## Department of Planning and Environment

### **New Educational Campus at 207 Barry Way, Jindabyne (SSD-15788005) Response to Submissions Report**

## **ATTACHMENT A – RESPONSE TO SUBMISSIONS AND REQUEST FOR INFORMATION**

Figure 4: Active transport site access

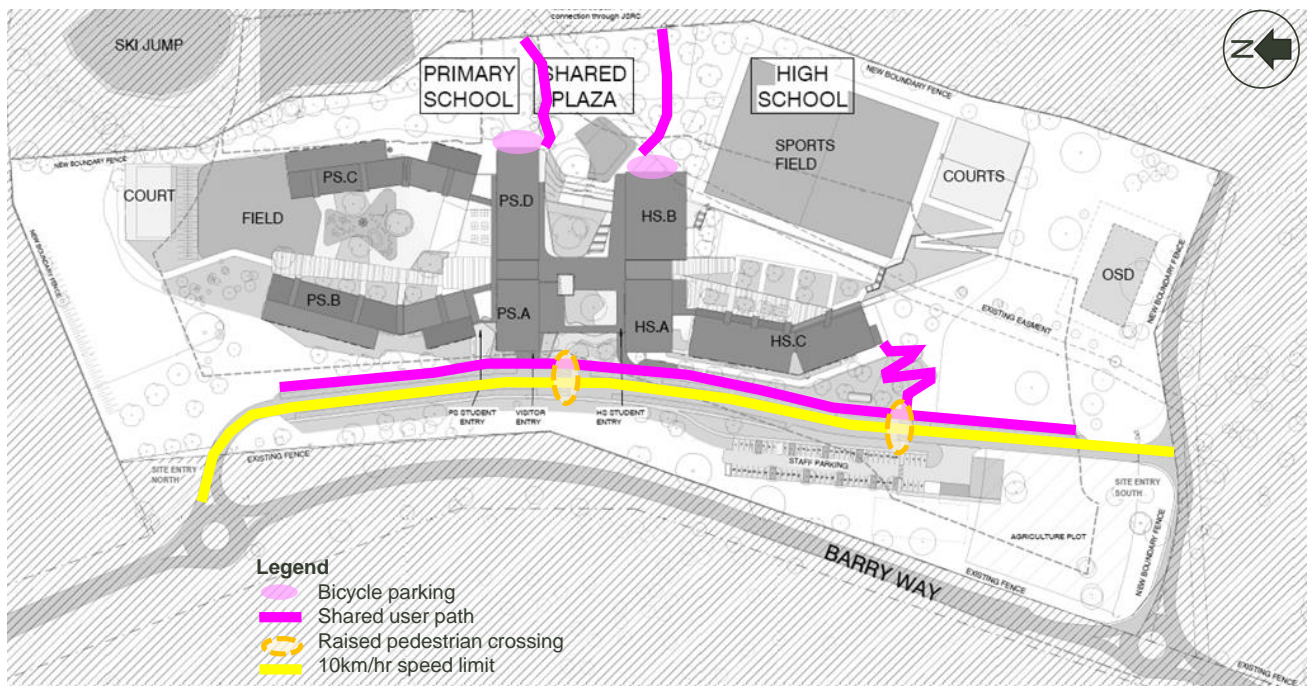
The CPTED report should address pedestrian access to the school. The proposed pedestrian access to the east of the school would be through a portion of isolated areas, away from opportunities for passive surveillance. The Department requests that the CPTED reports include an investigation of the pedestrian access with respect to the adopted CPTED principles.

**Figure 11: Proposed ground floor plan**  
 Source: DJRD Architects

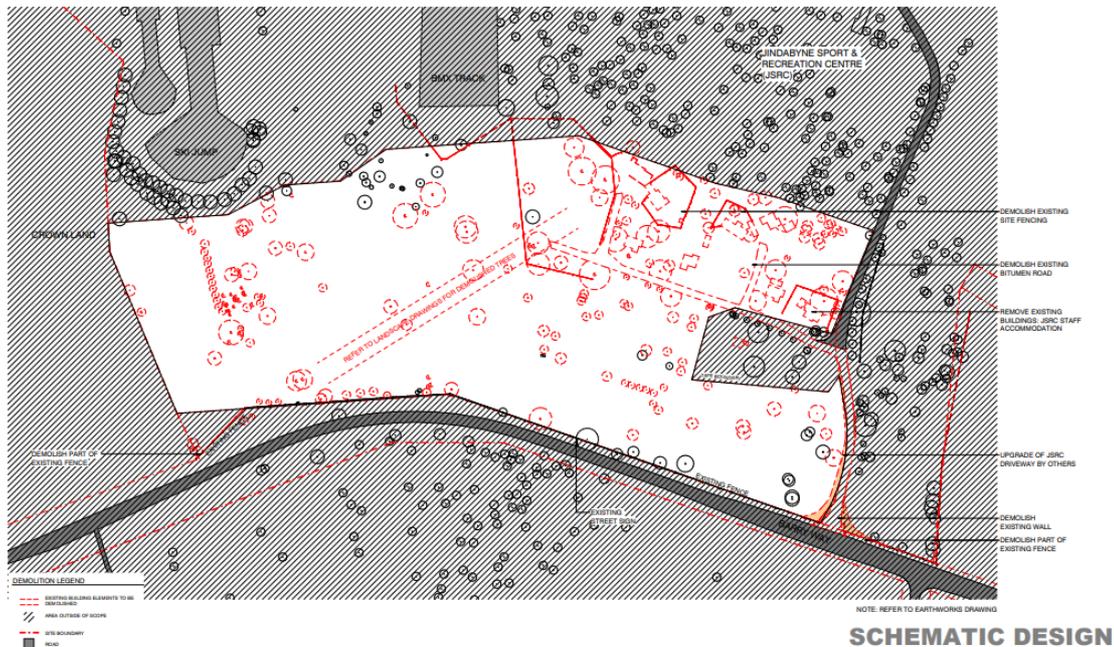
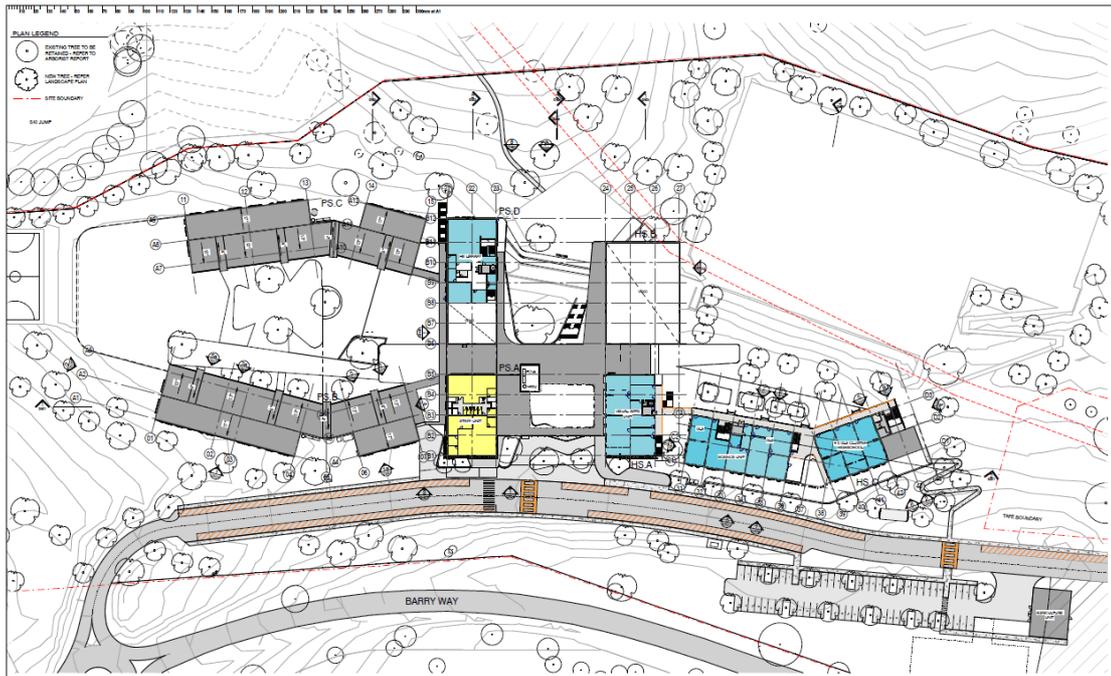
The submitted architectural plans have not provided clear floor plans for rooms within the education campus, with the only plans provided at a scale of 1:500. The Department requests detailed floor plans of all internal rooms that can be utilised as part of the assessment (drawn at 1:100 or 1:200).
